# Hothersall Parish Council

Re: Planning Application No: 3/2025/0653

Hothersall Parish Council wish to object to the Section 73 application for the variation of Condition 2 relating to the elevations and roof design of this development. In particular we wish to raise the following points and objections:

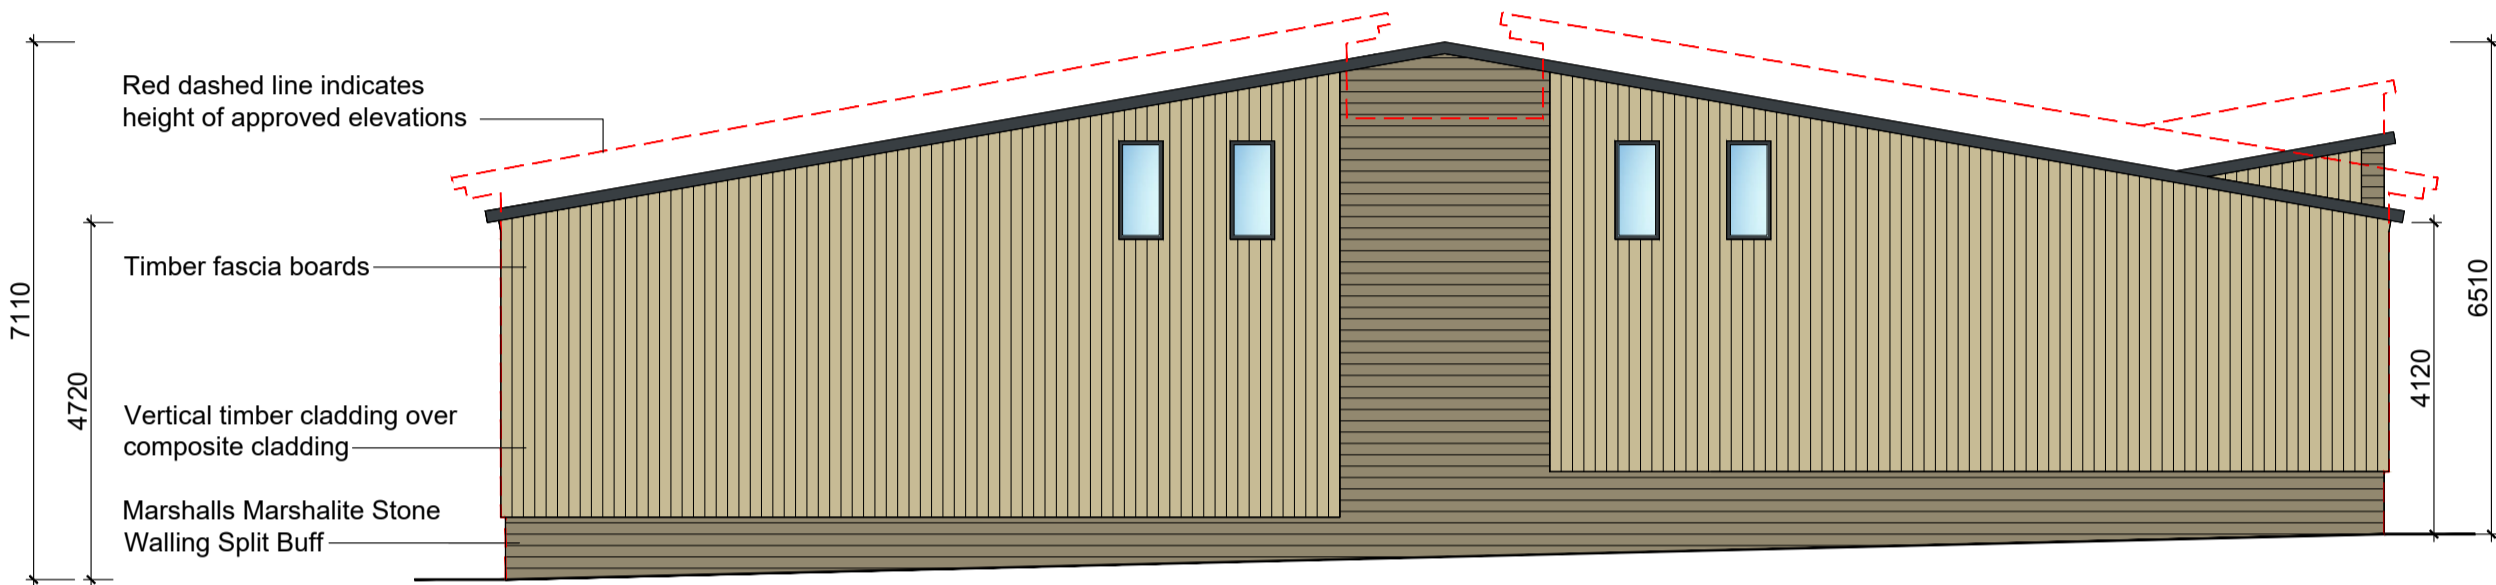
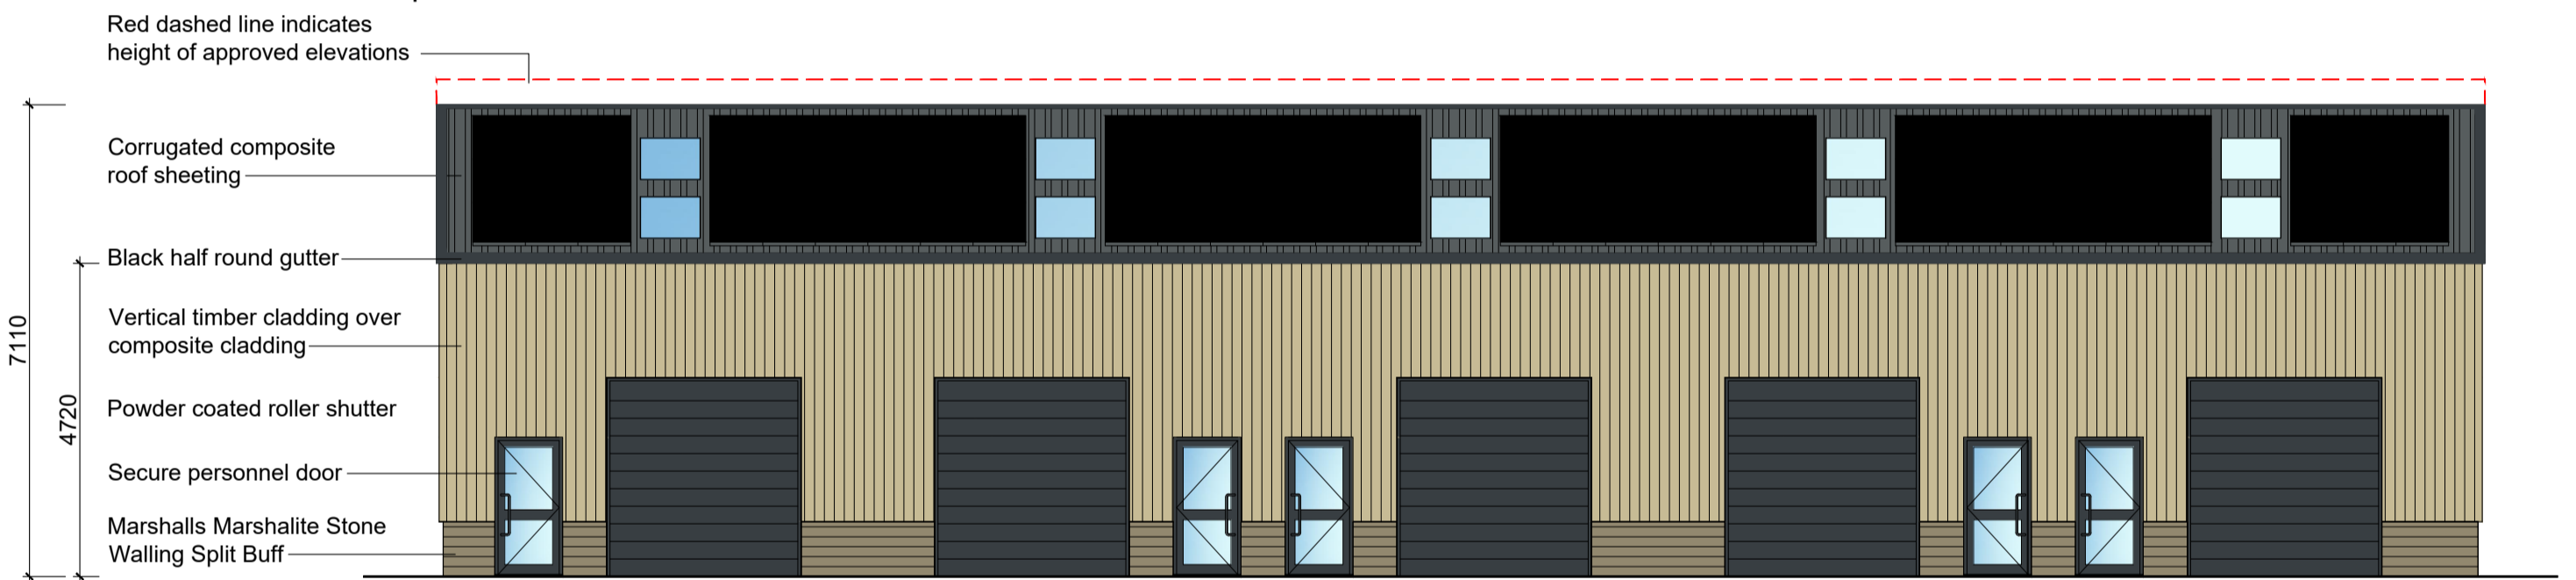
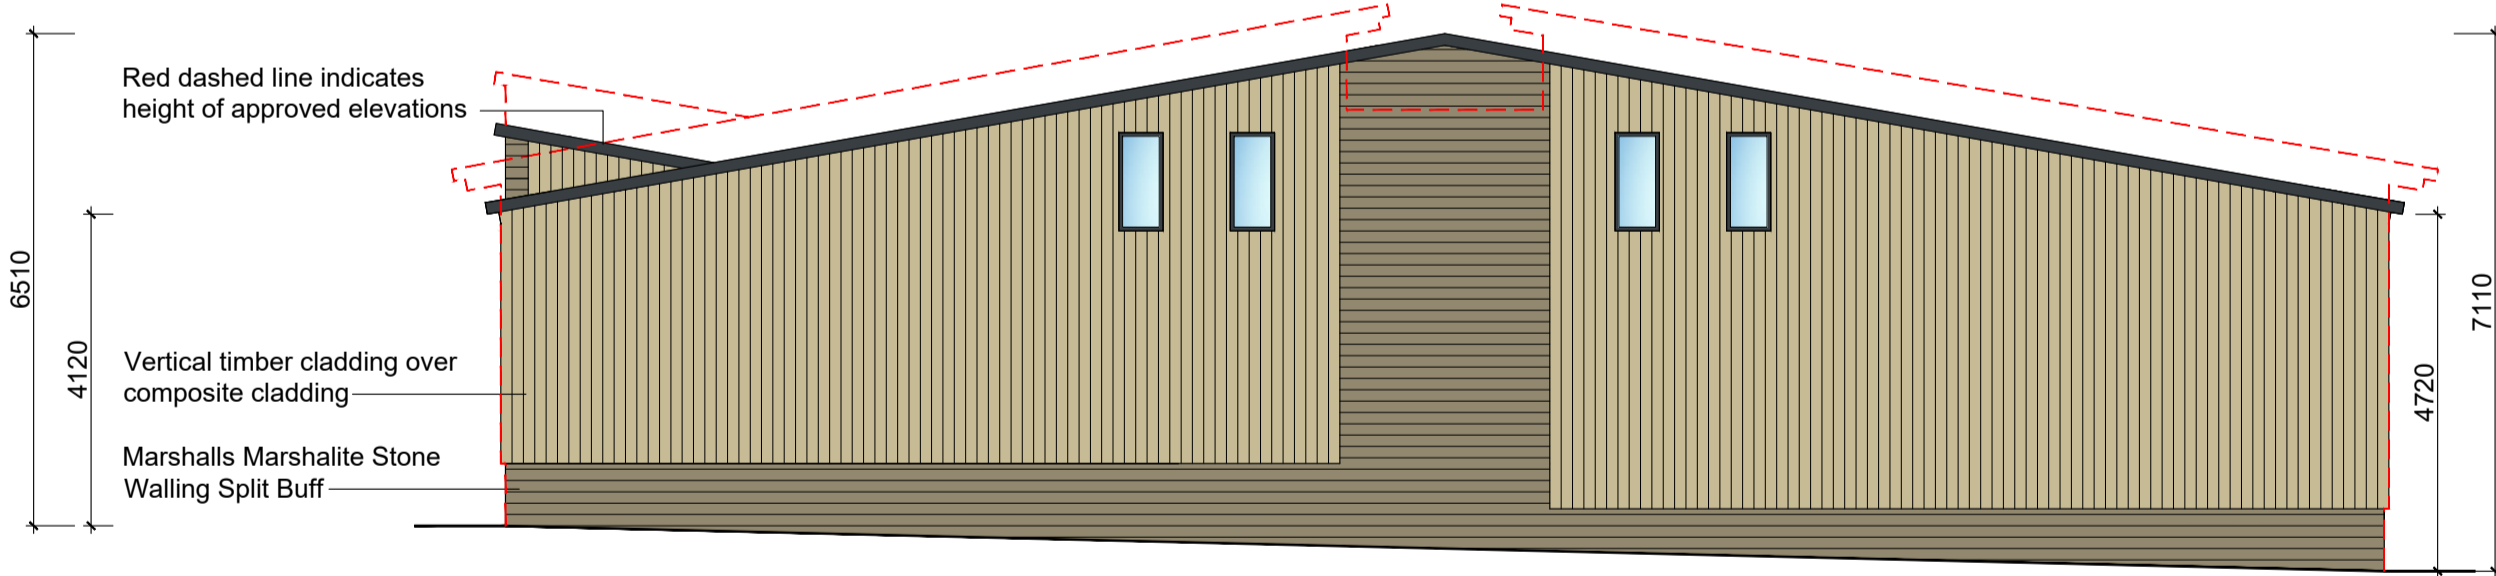
2. In paragraph 4.2 of the Planning Statement, the applicant refers to the planning committee refusing the previous application in November 2024 due to its uniformity and utilitarian form. This current application requesting a variance to the elevations and roof design, firmly returns the design to the original uniform and utilitarian form on which the previous application was refused by members.

3. Paragraphs 7.22 and 7.23 of the Planning Statement refer to Paragraphs 131 and 135 of the National Planning Policy Framework (2024), which state that "good design is a key aspect of sustainable development" and "add to the overall quality of the area, not just for the short term but over the lifetime of the development". It is the view of Hothersall Parish Council that the proposed simplification of the design elevations and roof design from the March 2025 approval, does not satisfy either of these requirements.

4. Paragraph 8.3 of the Planning Statement acknowledges that the recessed elements in the approved scheme contribute to softening the appearance in its semi-rural setting, but goes on to say that the revised elevations achieve a "comparable outcome". This is incomprehensible as the elevations and roof structures are completely different and have been simplified.
